20170560.1/2604A/R0/

26/04/2018

Hornsby Ku-ring-gai Hospital Stage 2 Redevelopment - Response to Planning NSW Queries

This letter has been prepared in response to comments made by the Planning NSW in an email received regarding the Revision 4 of our *SSD Acoustic Assessment* (dated 28/03/2018) for the Stage 2 Redevelopment of the Hornsby Ku-ring-gai Hospital.

LEVEL 6 - PLAN - PLANT

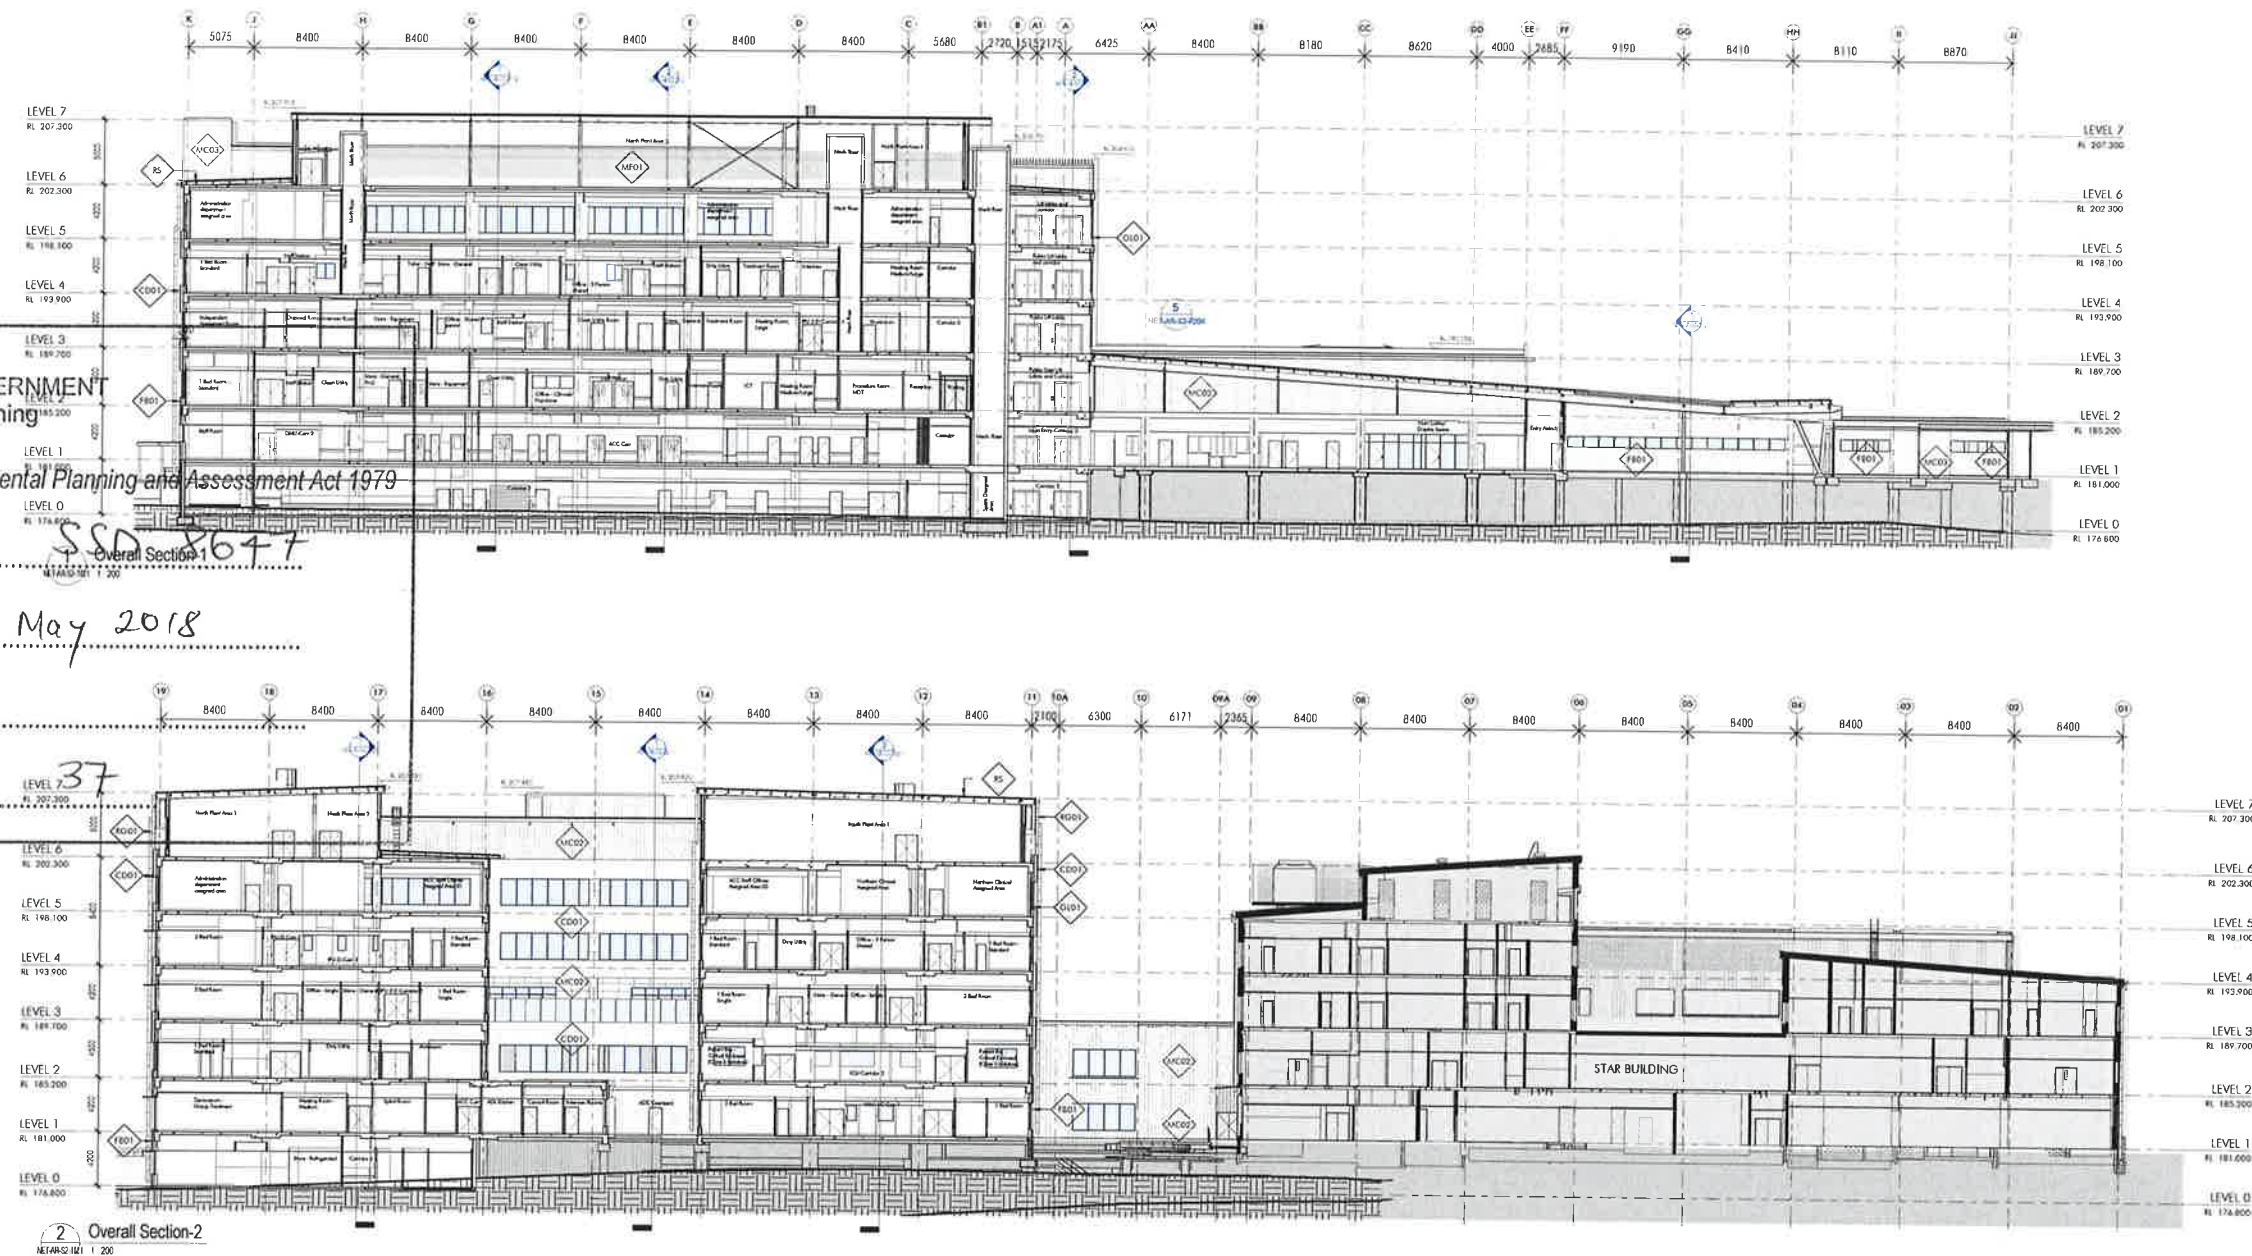
Point (iii) of the Planning NSW comments states noise from mechanical plant servicing the Stage 2 redevelopment has not been adequately assessed. Specific mention was made with respect to potential noise from the new generators (Level 6 plant room). This is addressed below:

- Level 6 plant room.
 - The east facing louvres are the most critical aspect of the Level 6 plant room (closest to the Derby Road residences).
 - Plant room design is such that it is primarily air handling units and return air fans that are located adjacent to the eastern louvres. The case radiated noise from these units is typically one of the quieter plant room noise sources (compared to chillers, pumps, generators etc).

- Despite this, the eastern louvres of the plant room is likely to need to be blanked off (6mm fc sheeting or 1mm steel sheet) to ensure noise emitted is compliant with the 35dB(A) noise target for Derby Street.

- Chillers (assumed sound power of 102dB(A)).
 - Three chillers are proposed to be located within the Level 6 plant room.
 - The plant rooms housing the chillers should not have any external ventilation opening/louvre.

- Outside air intakes for the air-handling units would be ducted from the unit to the façade penetrating the blanking sheeting (to enable air intake without other plant room noise escaping). This outside air ductwork would need to be internally lined (indicatively 50mm thick) to ensure that the outside air ducting itself is not an excessive noise source.

- The eastern plant room façade is the primary operational noise source from the hospital to the nearest residences. The design of this ductwork will be such that the 35dB(A) noise limit at the Derby Street residences is achieved.

- The chillers would need to have partitions constructed around them, separating them from other areas of the plant room (in order to control noise breaking out through louvres from the remainder of the plant room). The bounding partitions to the generator area will typically need to be either concrete block (min 90mm) or an insulated stud wall construction (9mm fc sheet to each side of studwork with 75mm thick 11kg/m³ insulation to the cavity).

- Light weight cladding to external plant room walls and ceiling will potentially require internal plasterboard sheeting to ensure acceptable noise breakout through wall/roof to nearby receivers.
